Application no: 23/00916/DISC

Location: Heyford Park, Camp Road, Upper Heyford, OX25 5HD

Transport Development Control

Recommendation:

HEYFORD PARK - OBLIGATIONS LAND PLAN

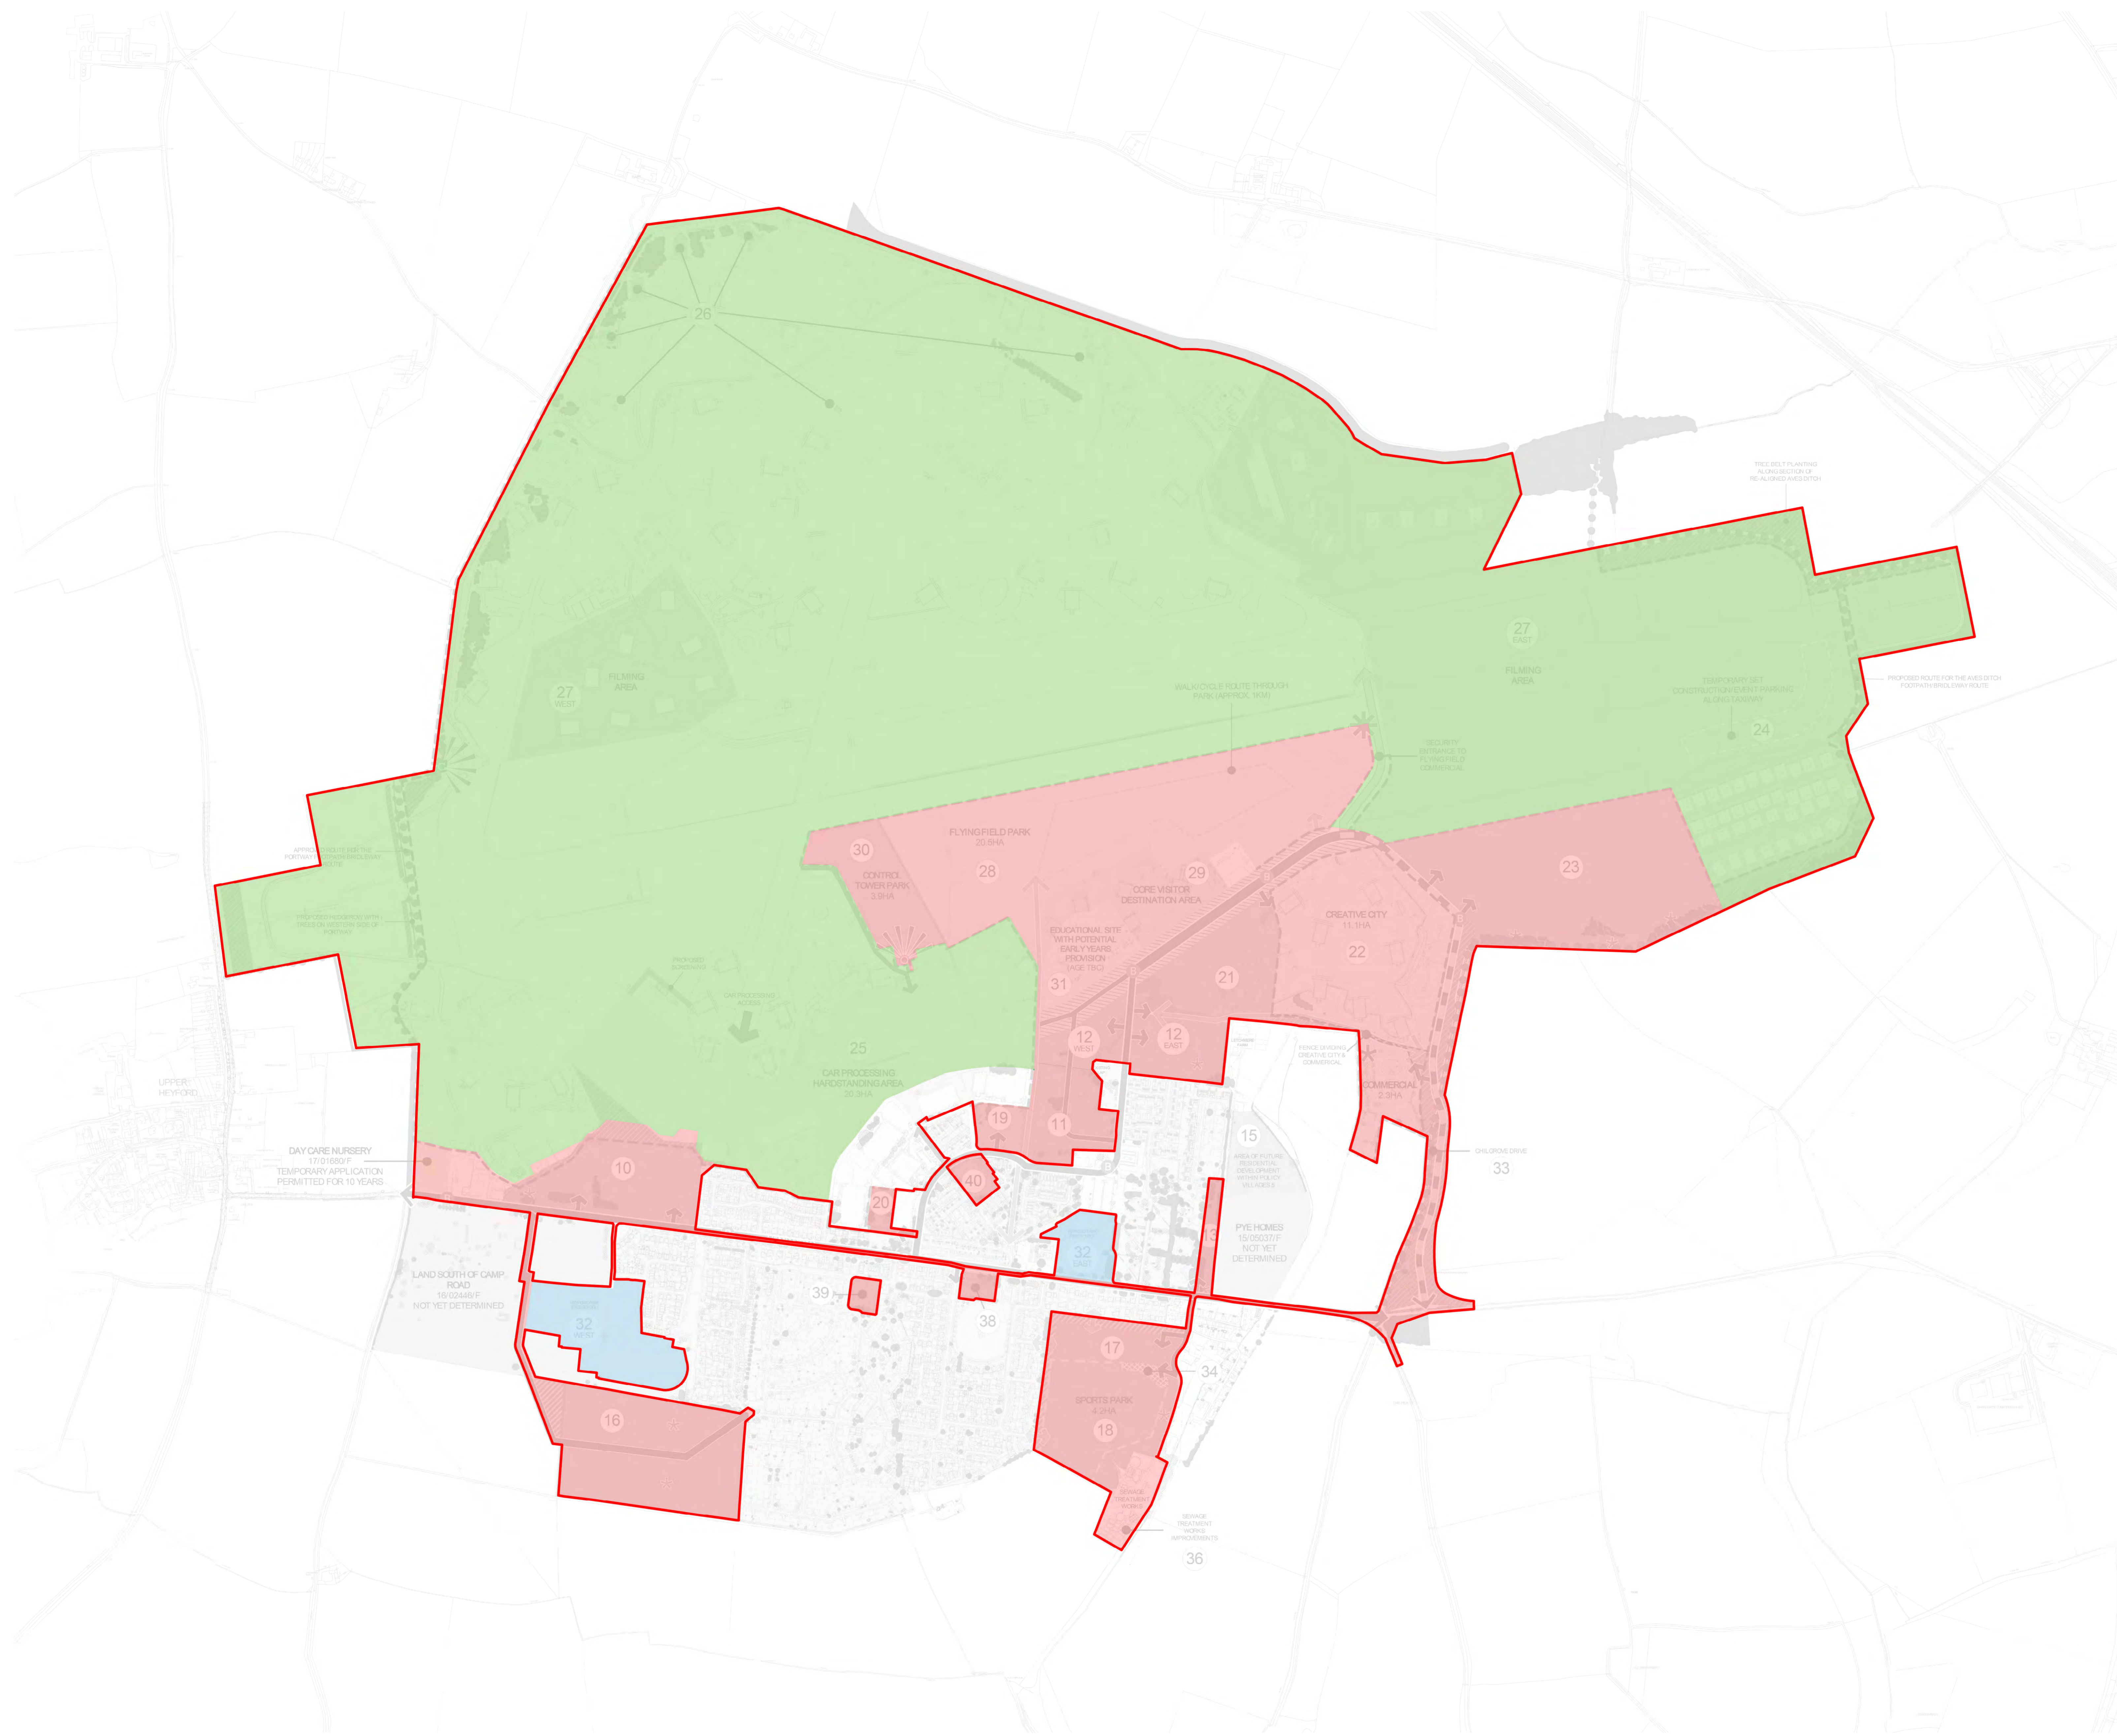
- 1) The route of Aves Ditch bridleway, required under condition 30 on the original development and more than a decade overdue/in breach has not been discharged – in that the route has not been agreed and the bridleway has not been provided for. As it stands the route could cut straight across the flying field, across the nib or one of a number of options and so it is inappropriate to agree fencing without knowing for sure how the bridleway will be accommodated.
- 2) The proposed fencing obstructs the potential route for the Aves Ditch bridleway in a number of places. The bridleway is required to be a 10m+ corridor without any obstructions across it – and the sketch below shows the locations where there seem to be restrictions.

This development should meet its obligations regarding Aves Ditch bridleway and get it reopened before any other development work progresses and before any other applications are considered.
